PORTLAND MAINE

RE: 71 Allison Avenue – 370-A-24 – R-2 Residential Zone – Permit App. #09-0958

I am in receipt of a permit application to remove an existing deck and to build a new 12' x 12' covered porch with a 12' x 16' deck. Your permit is denied because it is not meeting the requirements of the R-2 Residential Zone in which the lot is located.

73 Allison Avenue
 Portland, Maine

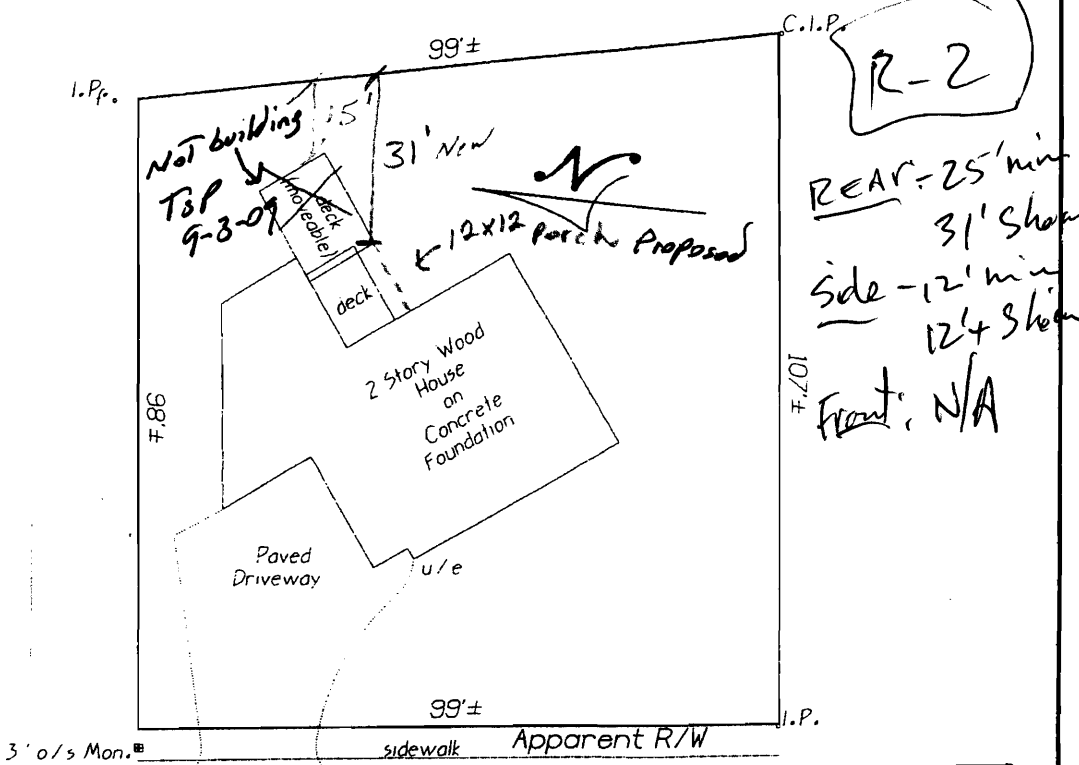
Section 14-80(d)2 of the R-2 Zone states that the minimum rear setback is 25 feet instead of the 15 feet shown on your submittal.

14-80(d)2
REAR Setback 25' min

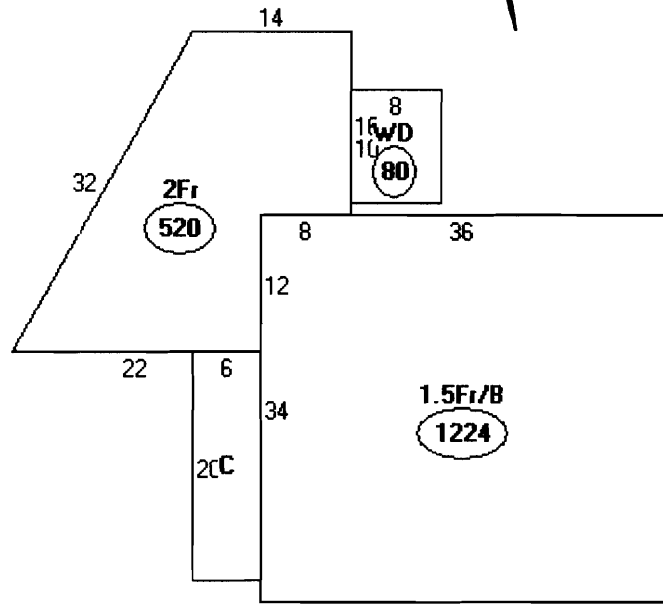
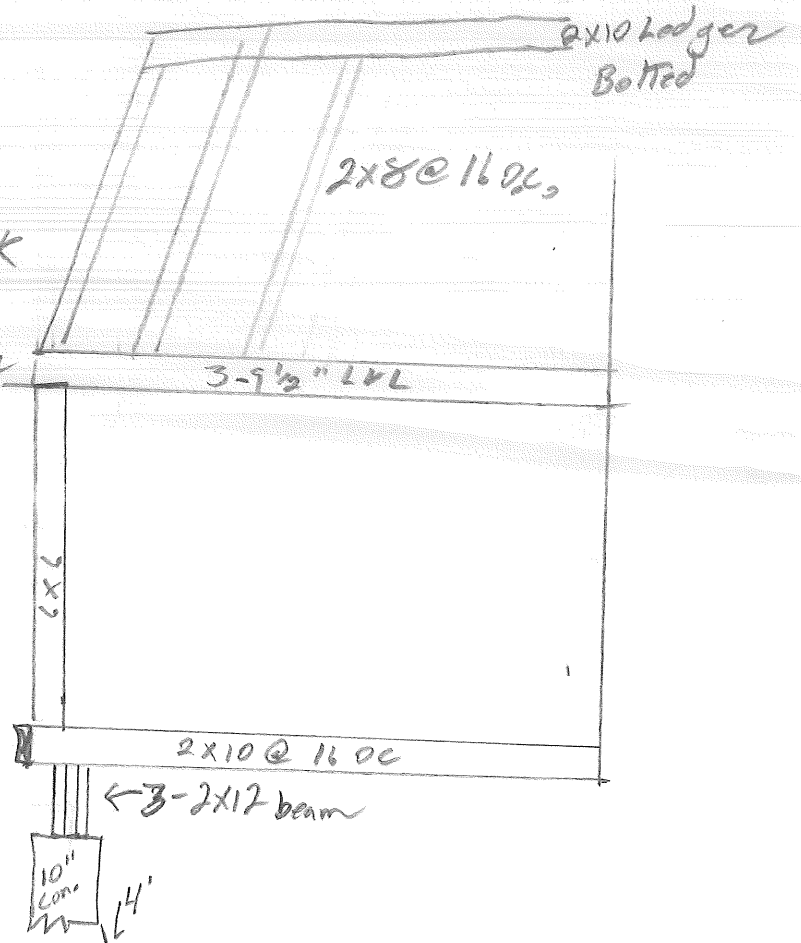
Section 14-80(e) of the R-2 Zone states that the maximum lot coverage is 20%. The Assessor's information states that the size of the lot is 10,136 square feet in size. 20% of 10,136 results in a maximum lot coverage of 2,027.2 square feet. My calculations result in a total lot coverage with the removal of the existing deck and a new covered porch along with a new deck, results in a total lot coverage of 2,200 square feet which is 172.8 square feet over the maximum allowed.

If you and your contractor can redesign your additions to meet the current R-2 Zone requirements, I will be glad to reactivate the permit and verify Zoning compliance. You also have the right to appeal my decision. If you wish to exercise your right to appeal, you have 30 days from the date of this letter in which to appeal. If you should fail to do so, my decision is binding and not subject to appeal. Please contact this office for the necessary paperwork required to file an appeal. If you have any questions regarding this matter, please do not hesitate to contact me at 874-8695.
